STAGE 1 & 2 ROAD SAFETY AUDIT

SECTION 278 ACCESS WORKS, FIELD HEAD LANE, BIRSTALL

Job Number	26019
Filename	Field Head Lane Stage 1 & 2 RSA
Issue No	1
Issue Date	09 th March 2026
Author	Tom Lyons
Reviewer	Chris Yarrow

No.	Revision	Date	Drwn
Status			
Client STONEWATER			
Project FIELD HEAD LANE BIRSTALL			
Drawing title S278 VEHICLE SWEEP PATH TRACKING			
Drawn RT	Chkd AD	Date SEPT 25	Scale 1:100
Contract No. 25469	Drw No. DR-C-0136-2	Revision	P2

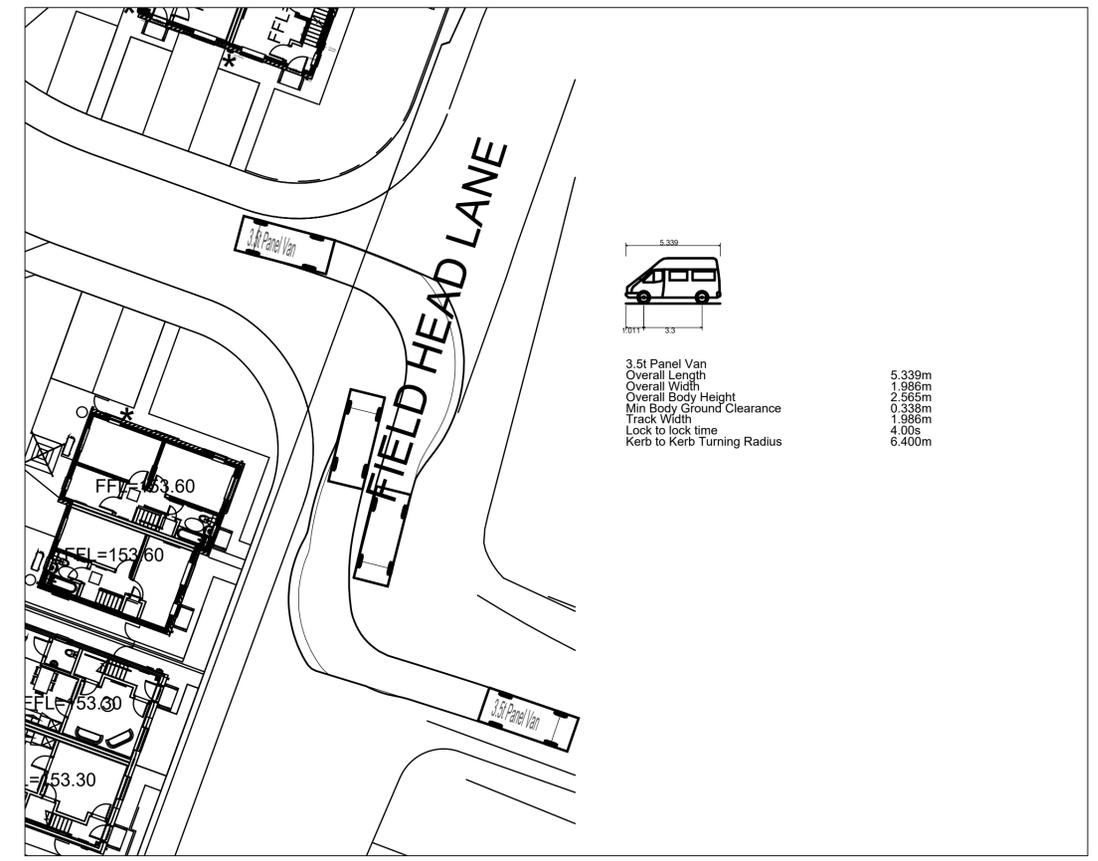
Problem 1	
Location	Site access off Field Head Lane.
Summary	No vehicle tracking analysis provided to demonstrate that there is sufficient carriageway available at the junction.
<p>It is not clear if there will be sufficient carriageway available to accommodate vehicle turning movements at the junction, particularly for large vehicles, if vehicles are parked directly opposite the junction on the east side of Field Head Lane. This will result in vehicles riding onto the footpaths and at risk of conflicting with pedestrians.</p>	
<p>The drawing is a detailed site plan showing four plots (Plot 3, 4, 5, and 6) and their access to Field Head Lane. Plot 3 has a Finished Floor Level (FFL) of 53.30. Plot 4 has an FFL of 53.30. Plot 5 has an FFL of 53.60. Plot 6 has an FFL of 53.60. Field Head Lane is shown as a road with a longitudinal tie-in joint. The drawing includes various annotations such as 'LIMIT OF FINISHED FLOOR LEVELS', 'LONGITUDINAL TIE-IN JOINT', 'FIELD HEAD LANE', 'BRICK HOUSE', 'TAR MAC', 'METAL RESURFACING', 'GRASS', 'BRICK WALL AND METAL RAILING', 'EAVES LEVEL', and 'HOUSES'. Yellow lines indicate vehicle swept paths at the junction. A stationing point is noted as 'STN 134.575 ± 422379.3190 N = 428979.1920'.</p>

Recommendation	
<p>It is recommended that vehicle tracking is undertaken and or waiting restrictions (yellow lines) are provided at the access junction to ensure that there is sufficient carriageway area available to accommodate all vehicle turning movements on and off Field Head Lane.</p>

DART HAVE UNDERTAKEN TRACKING AS SHOWN ON DRAWING 25469-DR-C-0136 P2 S278
VEHICLE SWEEP PATH TRACKING
